Application No: FG/94/20/HH
Site Address: 7 Little Drive Ferring BN12 5RF
Description of works: Conversion of roofspace to habitable use and conversion of roof from hip to gable end and single storey rear extension.

Thank you for your internet representation made on 22nd September 2020 which has been recorded as an objection with the comments as follows:

FIRST FLOOR PLAN.

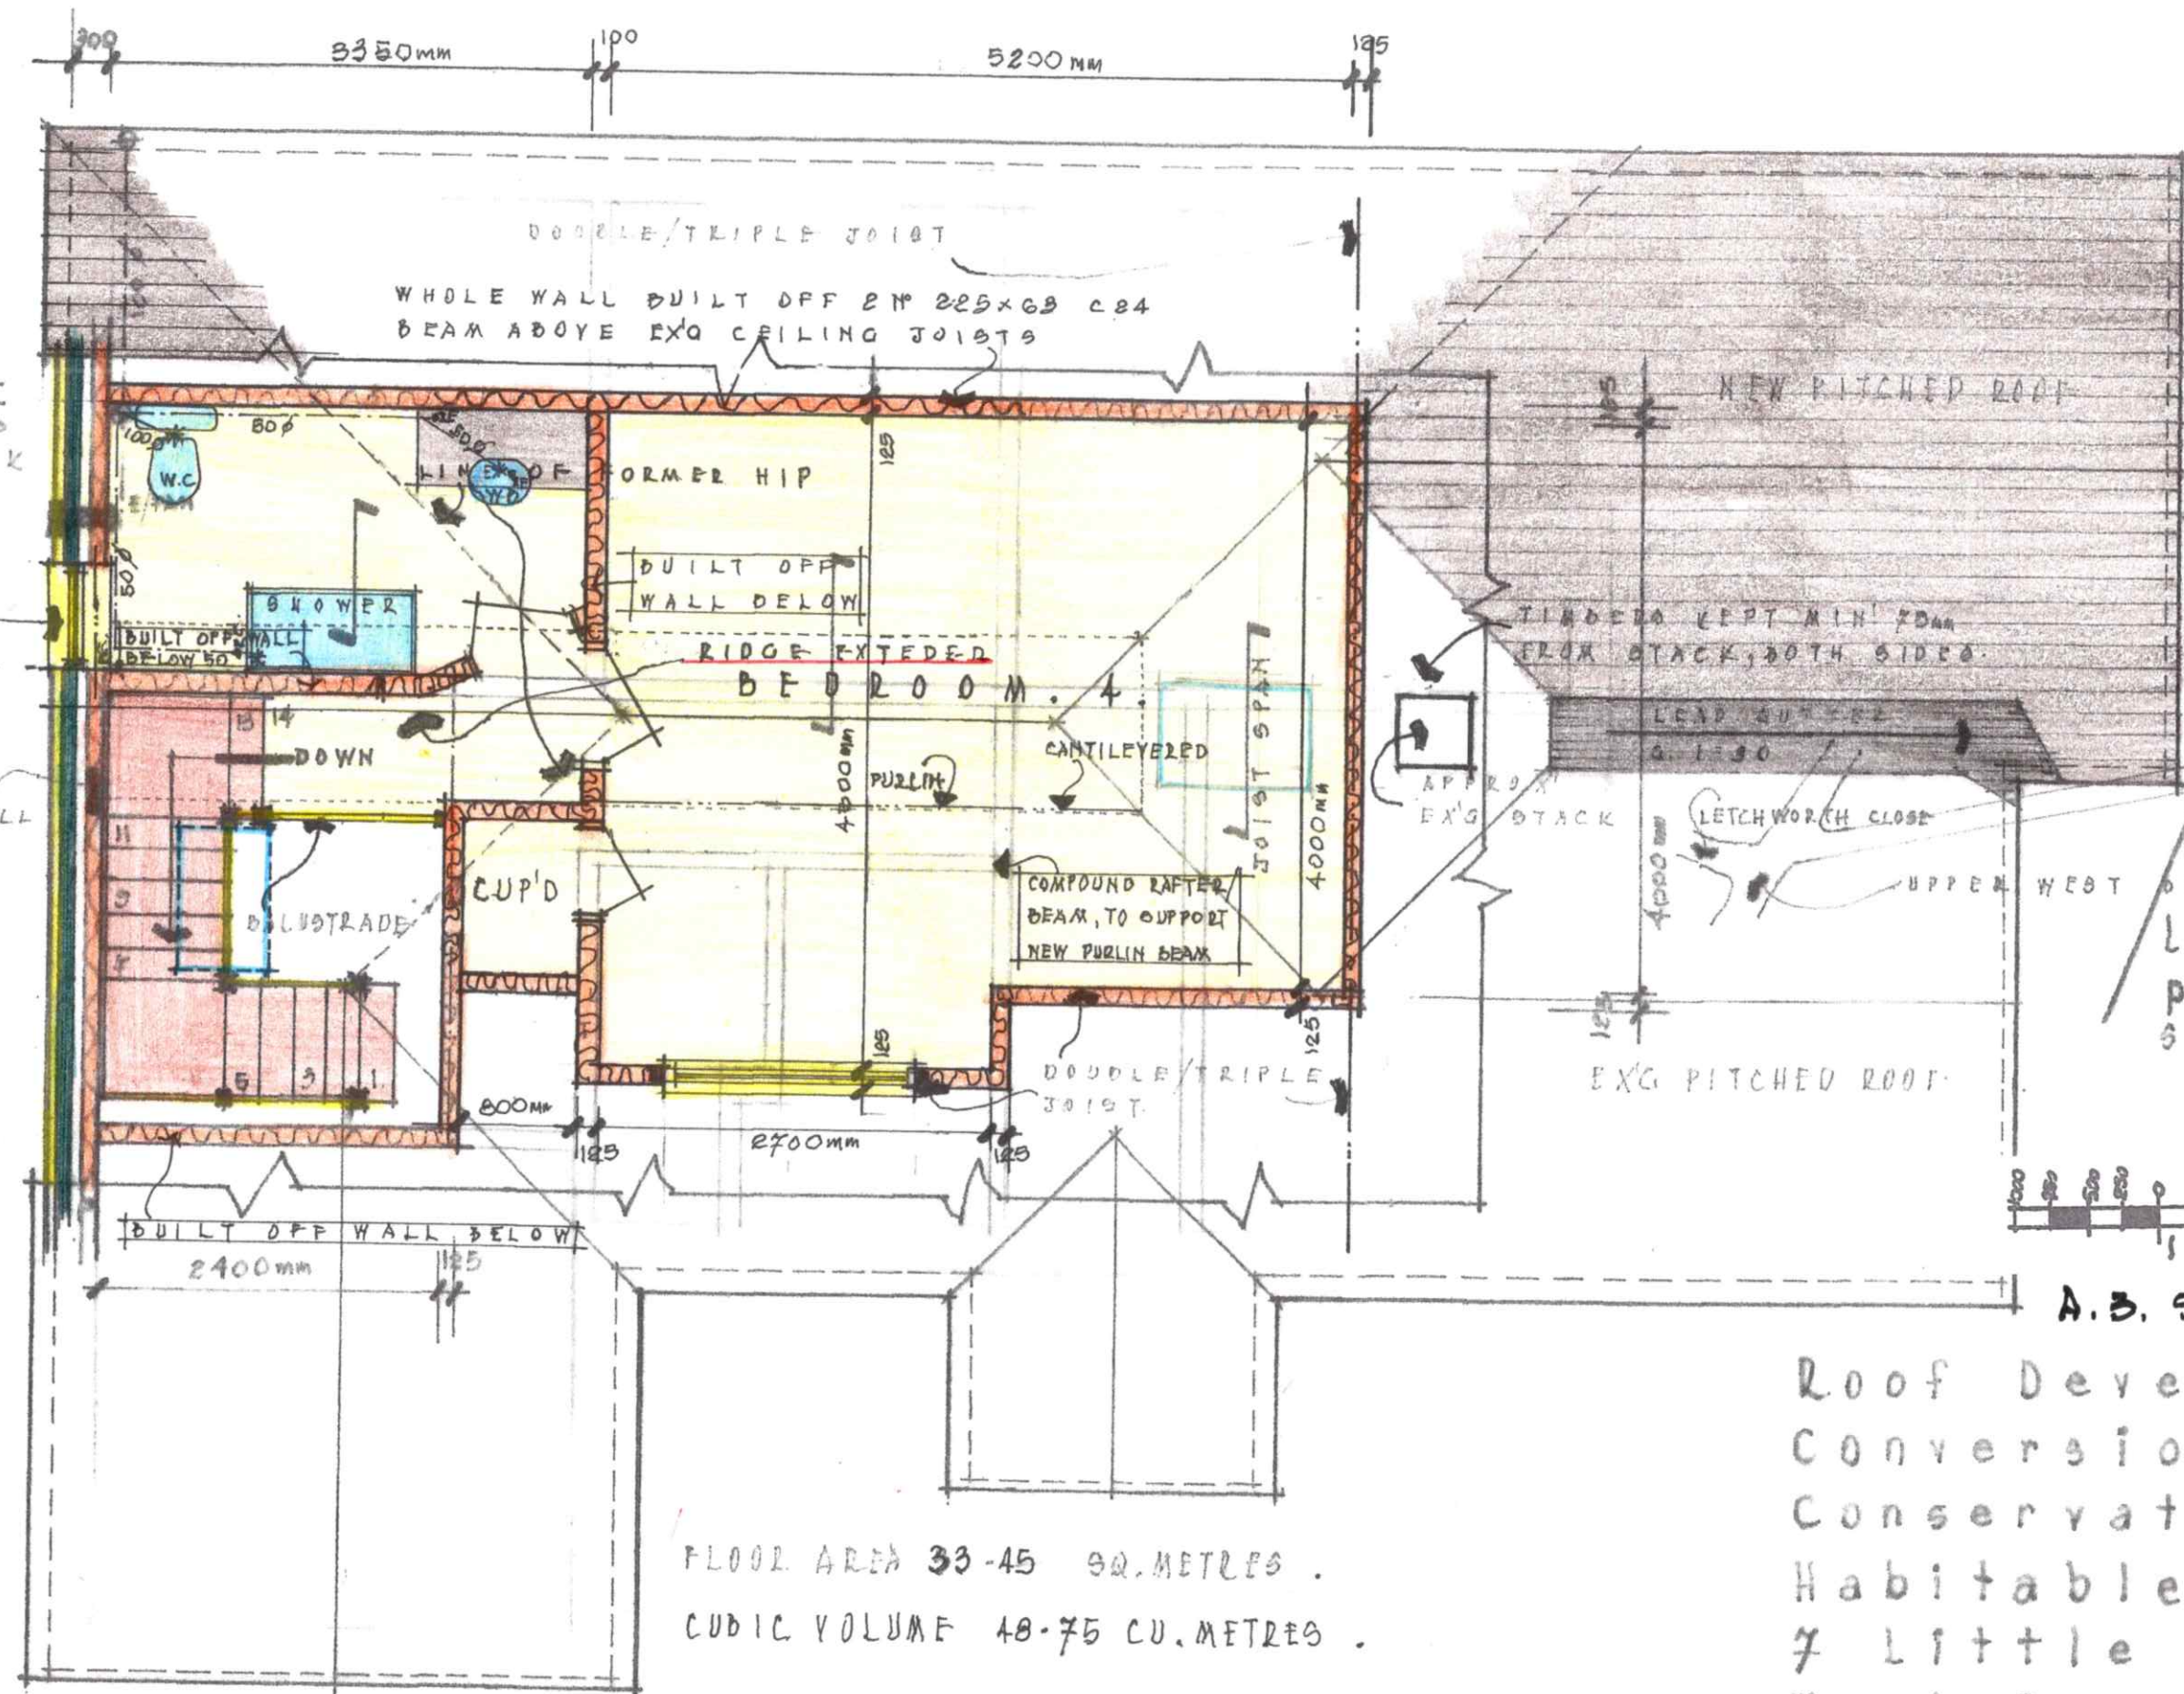
The proposed development is out of size and character of the neighbouring properties, the dormer will be directly overlooking the adjacent properties at 11 Little Drive and 14 Upper West Drive. The conversion of the hipped end to a gable end on the north elevation will also directly overshadow number 8 Little Drive and our property to the west.

Existing Plan,
Section And
Elevations Of
Property.

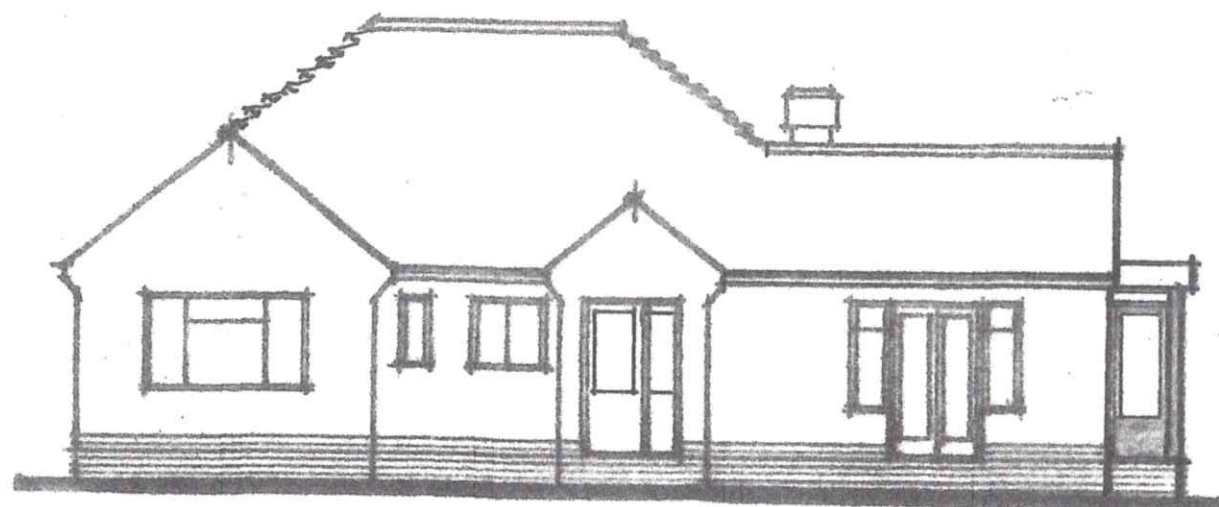
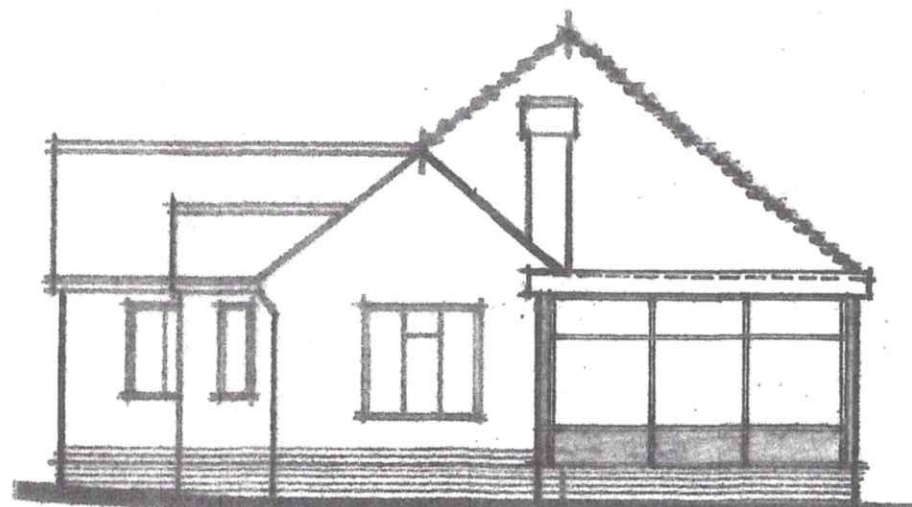
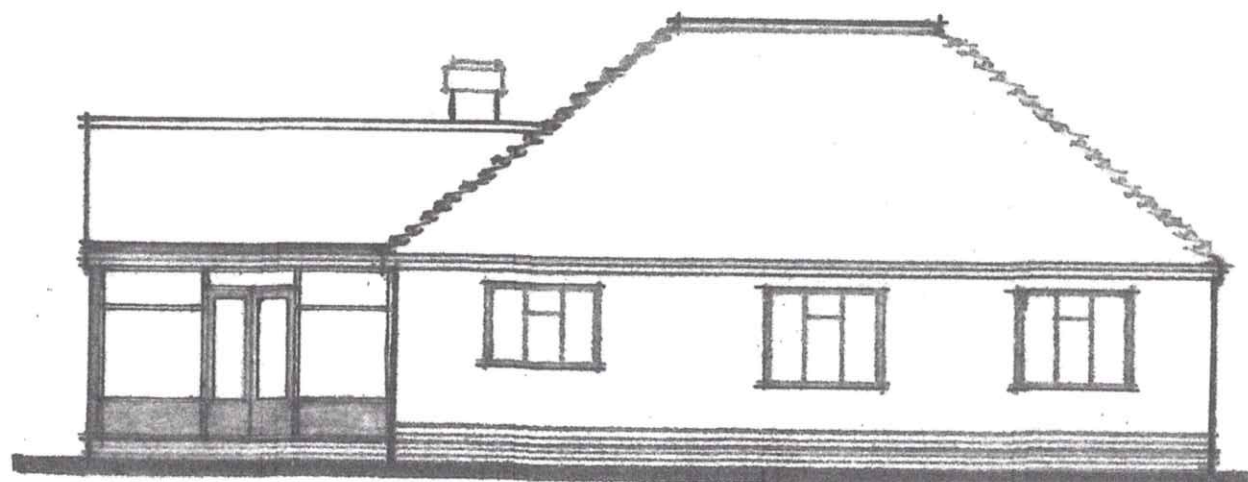
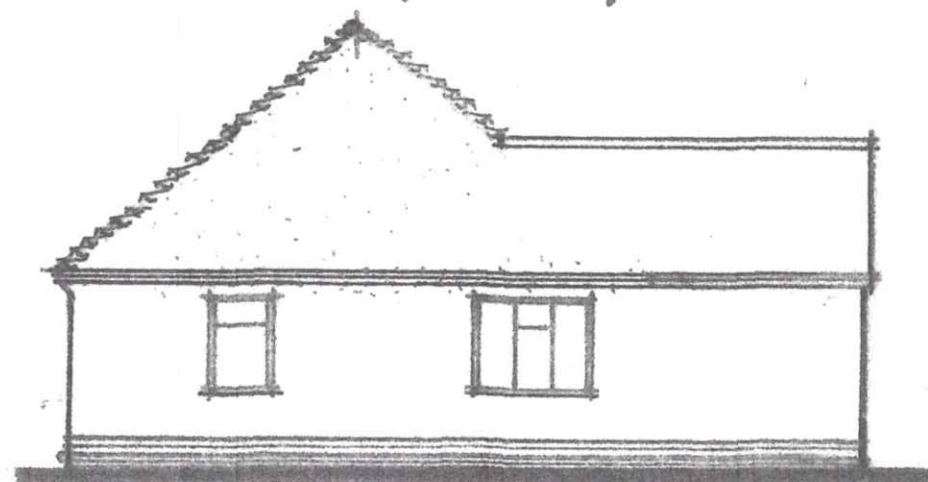
The plans submitted are not representative of the existing structure at the time of the application and the elevations are incorrectly marked. The owners of the property have already commenced works on the rear extension without planning consent. There was formerly a wooden glazed conservatory with a glazed flat roof on the south east corner of the property. This has been demolished and replaced with a new extension, with concrete cavity walls and a new pitched tiled roof altering both the footprint of the building and roofline, this is not shown on their planning submission as having already been completed. The photos submitted as part of this planning application are out of date and are not representative of the actual structure at the time of this planning submission either. This would appear to be an attempt to deceive both Arun Council Planning Department and all those parties affected by the proposal. The elevation drawings have also been incorrectly labelled, the front of the property faces west and the rear is in an easterly direction, however the front is indicated as east on the plan and the rear as west.
